Recommendation Report for Planning Permission for Works or Extension to a Dwelling

REF NO: WA/19/22/HH

LOCATION: 13 Oaktree Cottages
Barnham Lane
Walberton
BN18 0AY

PROPOSAL: Installation of a modular ramp to provide disabled access.

Drawing Reference HT/03/OaktreeCot13 Date 26/01/22

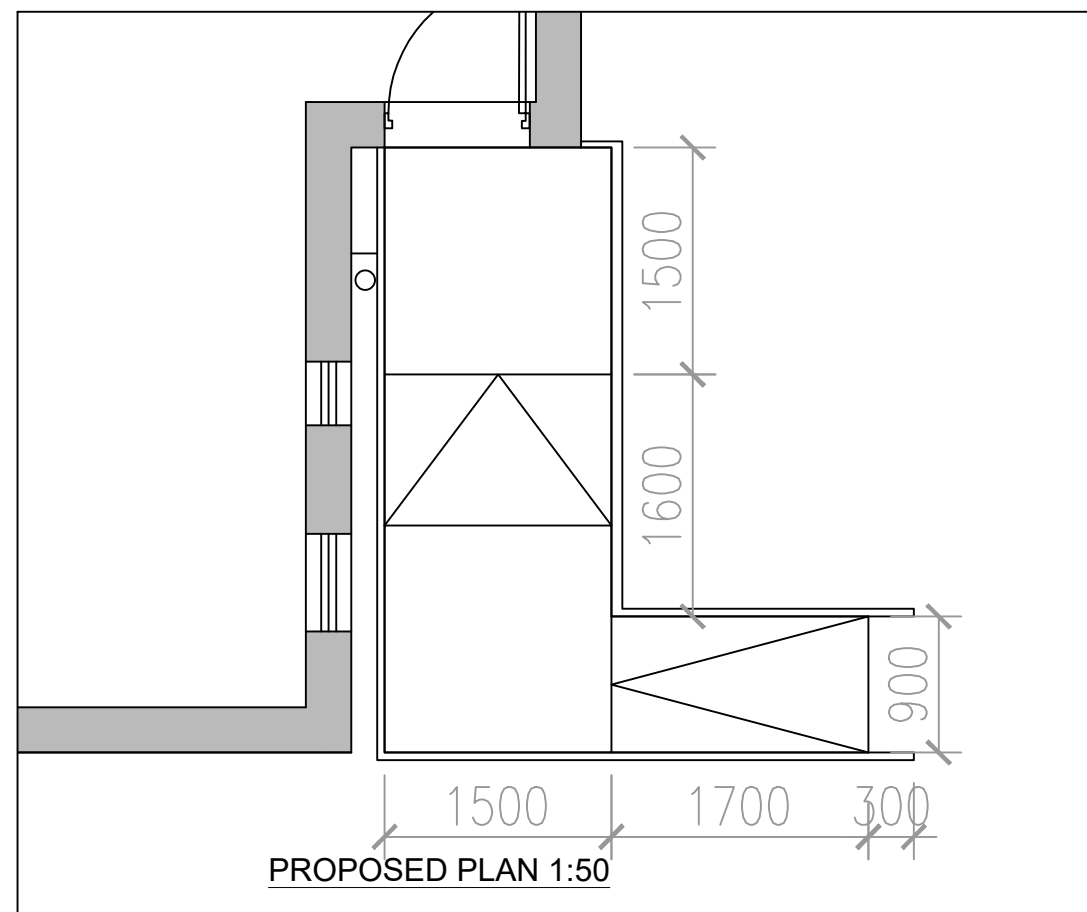
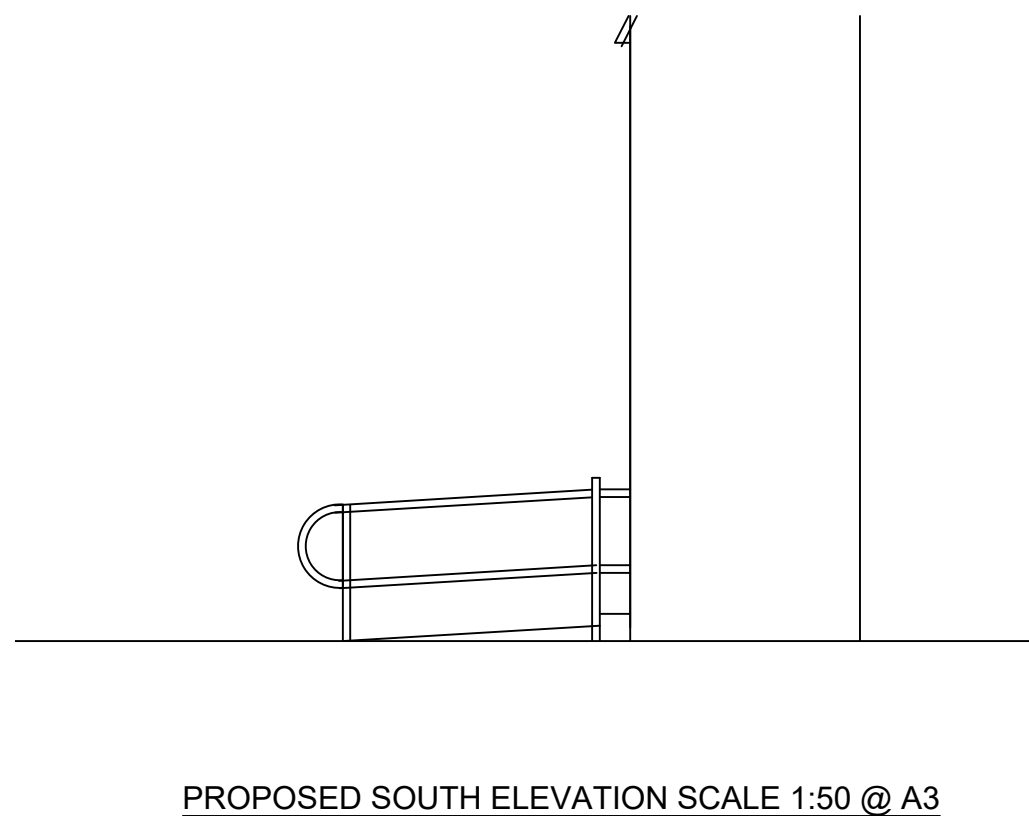
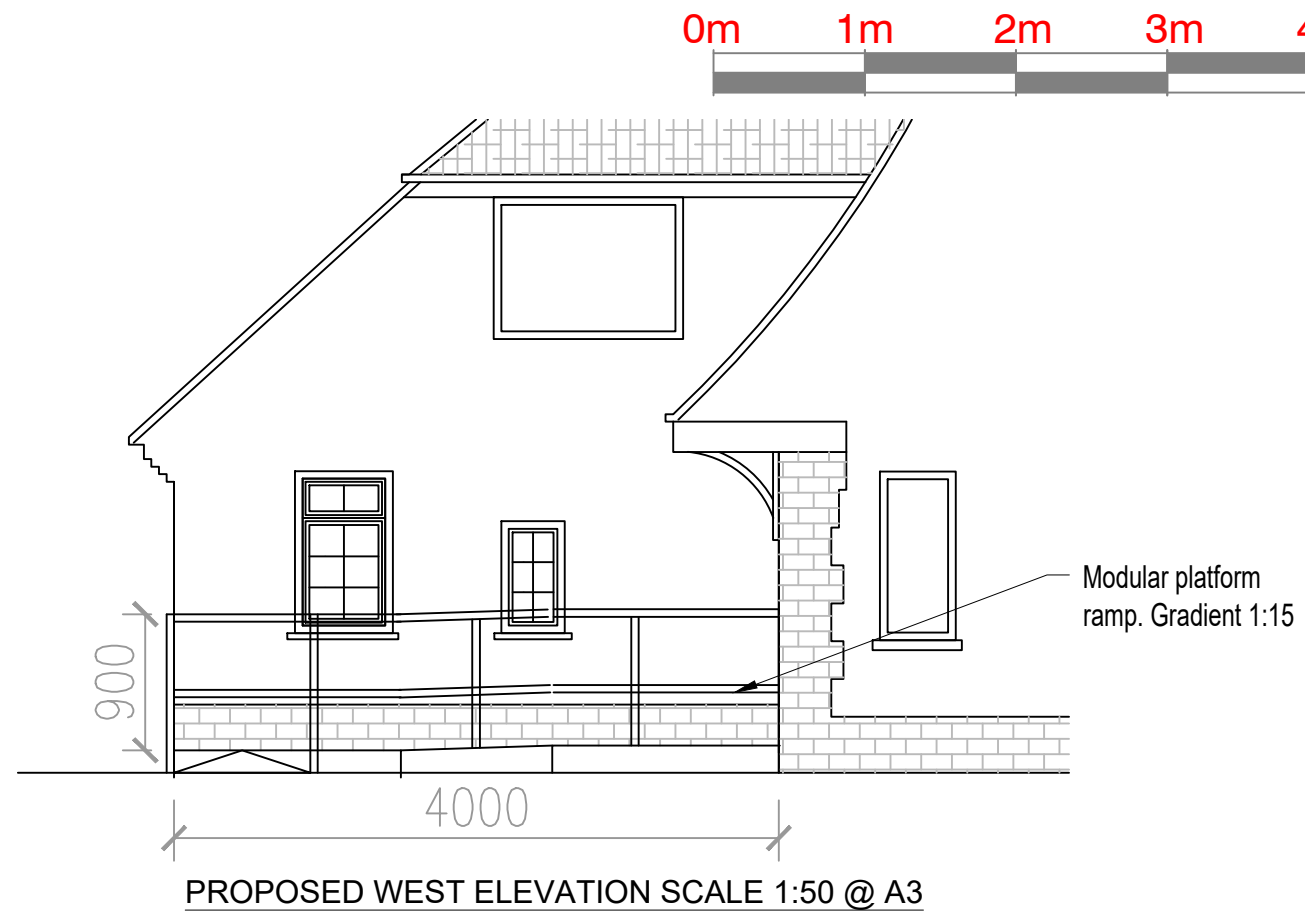
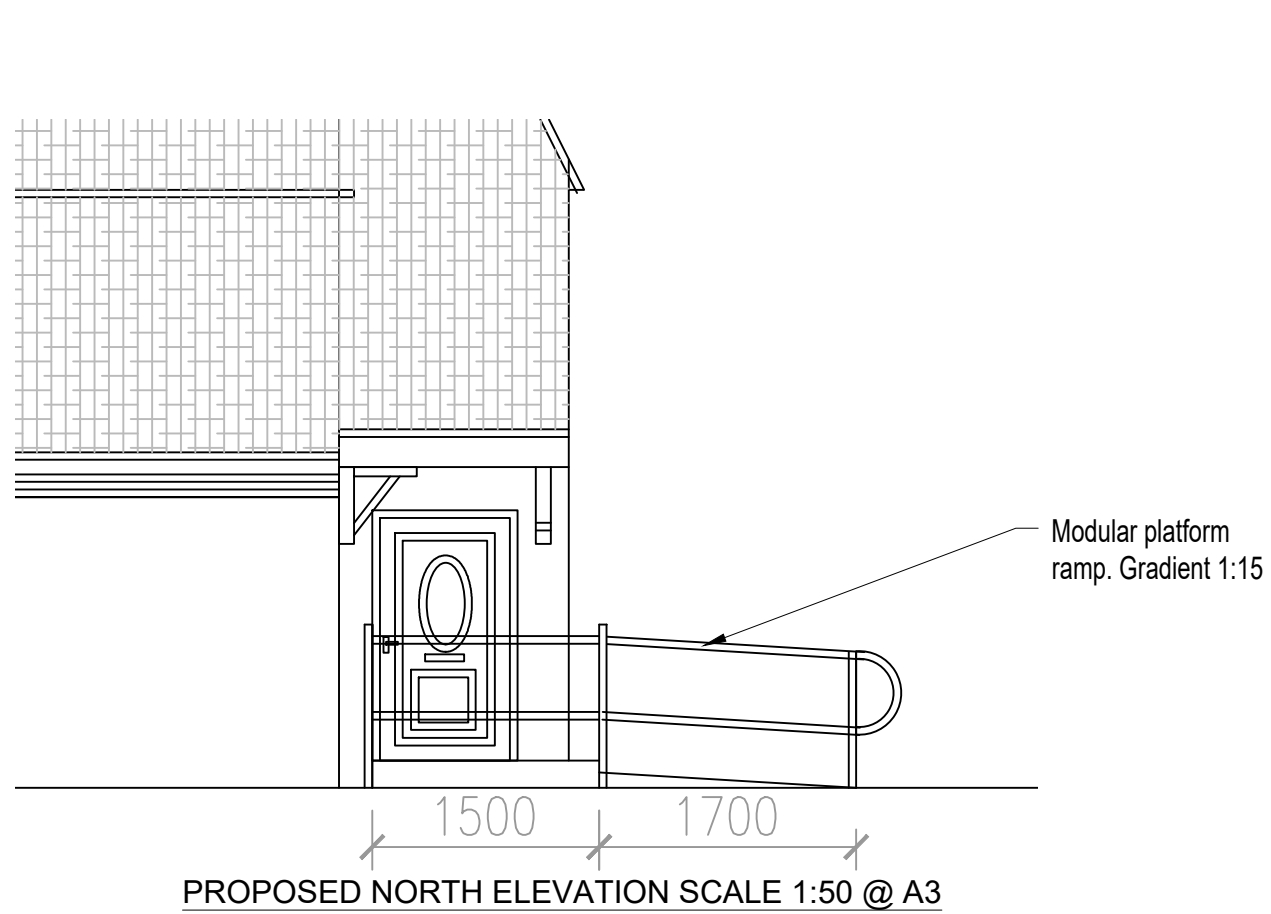
The ramp will be modular and L shaped, with two platforms and handrails at a maximum height of 0.9m. The first part of the ramp will have a width of 0.9m and depth of 1.7m, the second part measuring 1.5m wide and 4m deep, with a flat platform at the top providing access to the door. The ramp will be at a gradient of 1:15, which is a suitable angle for wheelchair/mobility impaired access, meeting standard regulations and providing easier access for the user. The proposal will retain 14m from the front boundary and will be visible from the street scene. Despite this, as it is set relatively far back from the street itself, the proposal will not visually impose upon the character of the area, and will have little harm on the appearance or composition of the street. The proposal will be of essential use to the resident, and as such the impact on visual amenity is acceptable.

The ramp will be to the front of the property and will have a maximum height of approximately 1.08m. Due to its scale, and location being at the front of the dwelling, it is not considered to result in adverse overbearing or overshadowing. It will retain 6.5m to the south west and 1.5m to the north east, and will have little harm on residential amenity. This is in accord with D DM4.
